**Application by AQUIND Limited for an Order Granting Development Consent for the AQUIND Interconnector Project**

**Written Submission - Deadline-6 for 23<sup>rd</sup> December 2020**

**APLEAL – Community Action Group**

Appendix 2 – Converter Station Access Drawing

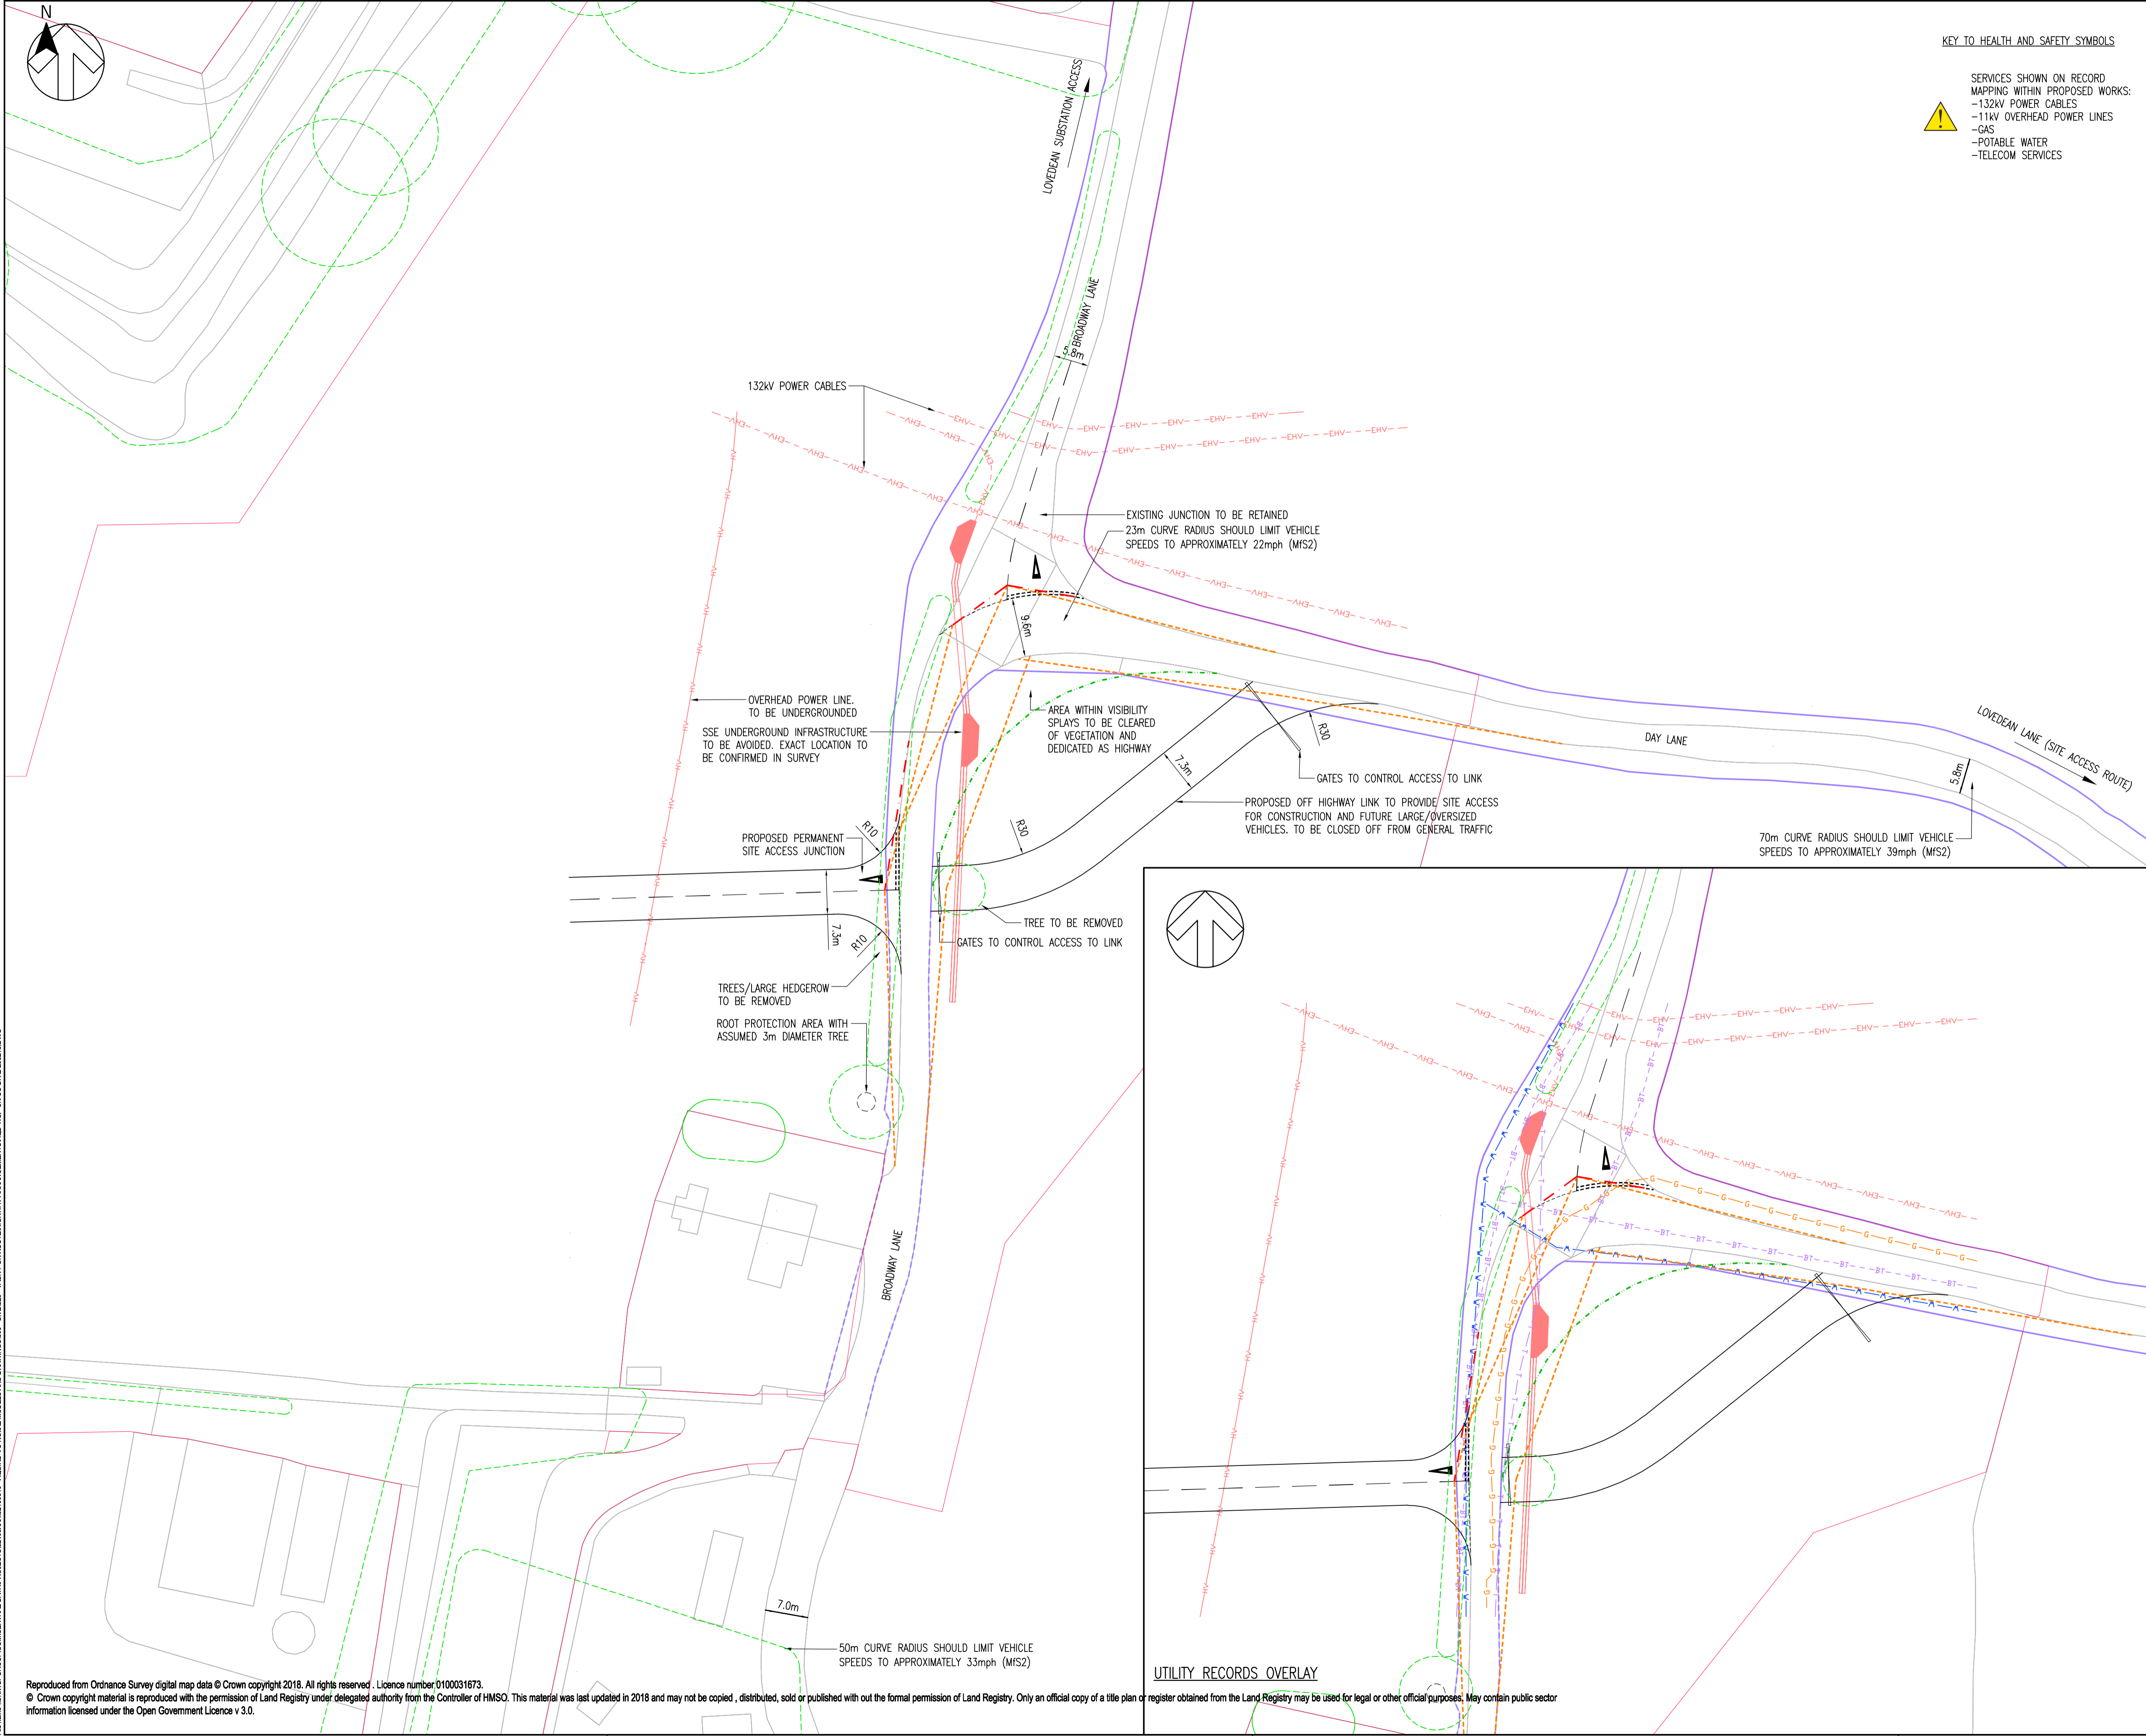
In our submission at Deadline-1, we made reference to traffic safety issues particular to Day Lane and its junction with Broadway Lane. In the submission, we acknowledged that numbers associated with accidents and traffic volume did not require any remedial work on the roads in question to meet the existing regulations. The response from the applicant was simply a repeat of what was contained in the AQUIND Proposal – no action required. This response is less than useful, as it does not seek to find a resolution or engage with local residents. In fact it shows a total disregard for the safety of local road users.

Our issue here is that because nobody chooses to walk or cycle up or down Day Lane as it is not fit for any non-motorised users. Pedestrians, in particular, have minimal verge to escape oncoming vehicles. The photo below shows the situation at the top of Day Lane.

The fact that minimal pedestrian use is made of Day Lane will distort any statistics and hence the conclusion. The proposed work to include a special slip road for the transformers offers a great opportunity to improve safety for pedestrians and others and be of benefit to the wider community. The cost of this would be minimal, especially compared with the costs that may be incurred by the project as the result of an accident.

We ask that the applicant reviews the arrangements for all Road Users using Day Lane and the junction with Broadway Lane. Not just site traffic.

Appendix 4 – Sensitive Receptors and Temporary Access Locations

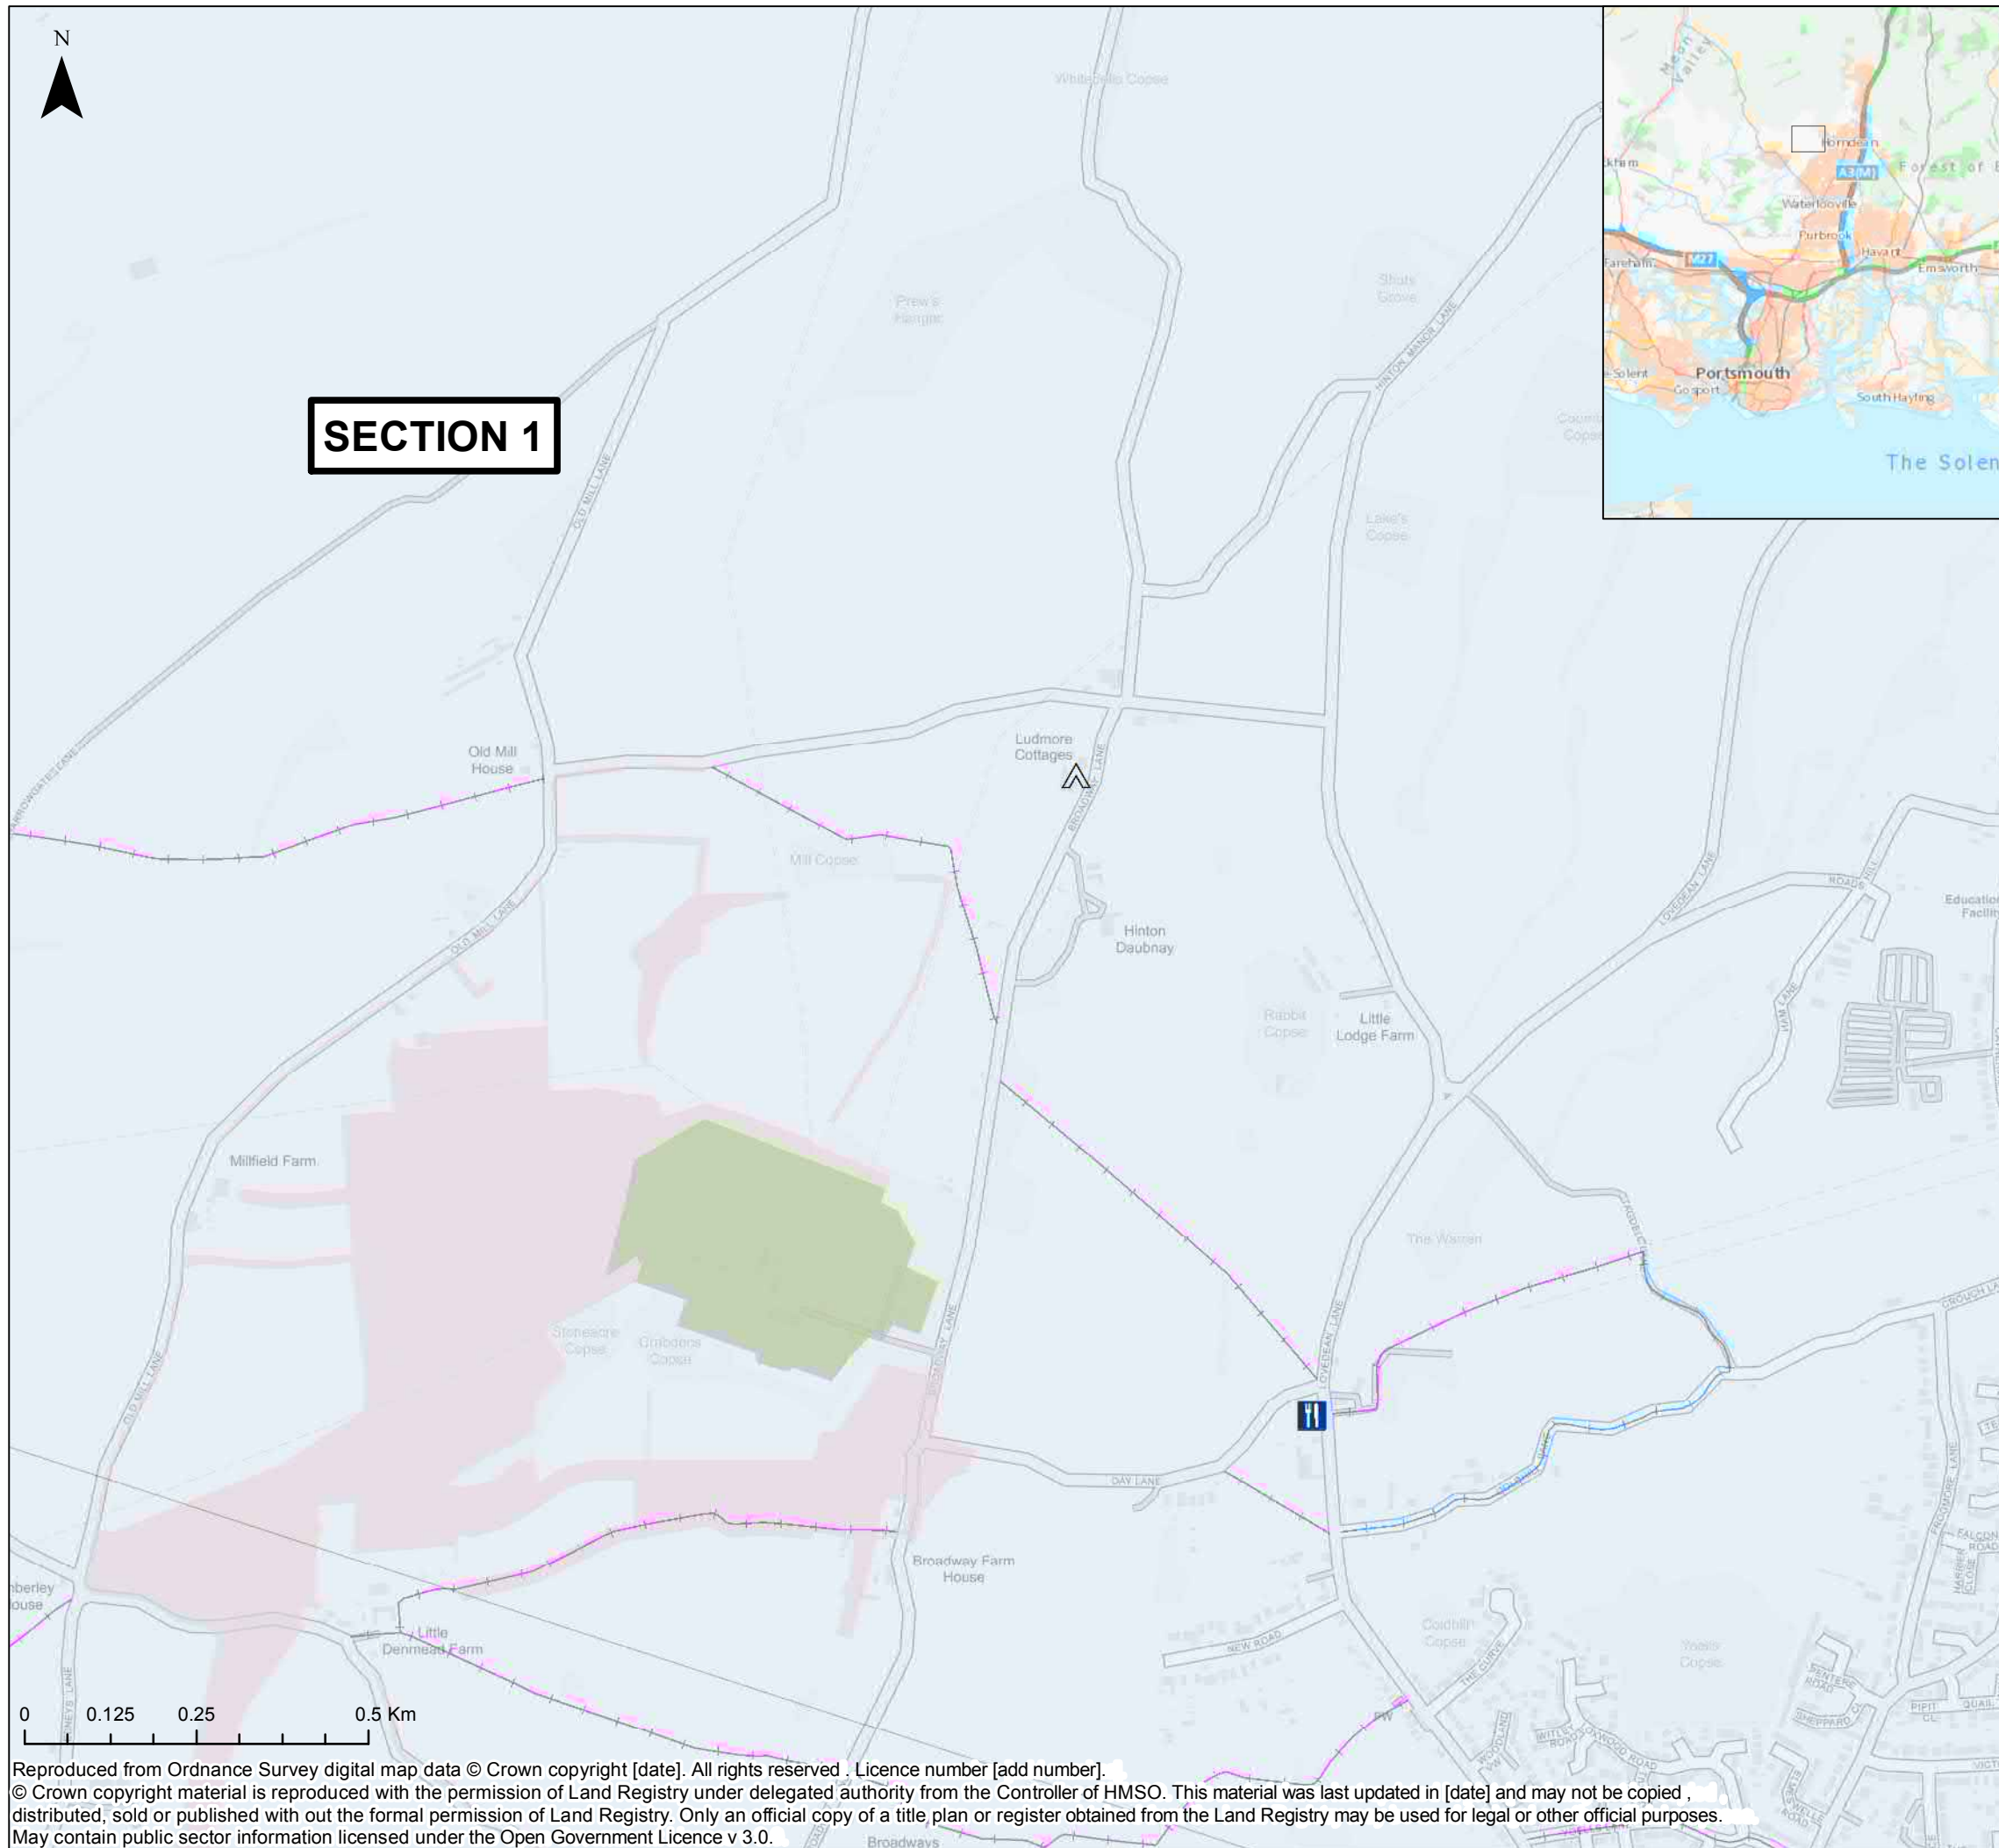
APLEAL has been previously informed that some short-term use will be made of the existing farm track from Broadway Lane, which leads to the Lovedean Converter site. We are now informed that this could extend up to 12 months. This entrance off Broadway Lane is also, the residential access to numbers 1,2 and 3 Broadway Farm Barn, 2, Broadway Farm Cottage and Little Lovedean.

Having to share the residential property access with a stream of construction traffic is a considerable incumbrance on all the residents. Our strong recommendation is that this access off Broadway Lane should not be used and alternative access sort.
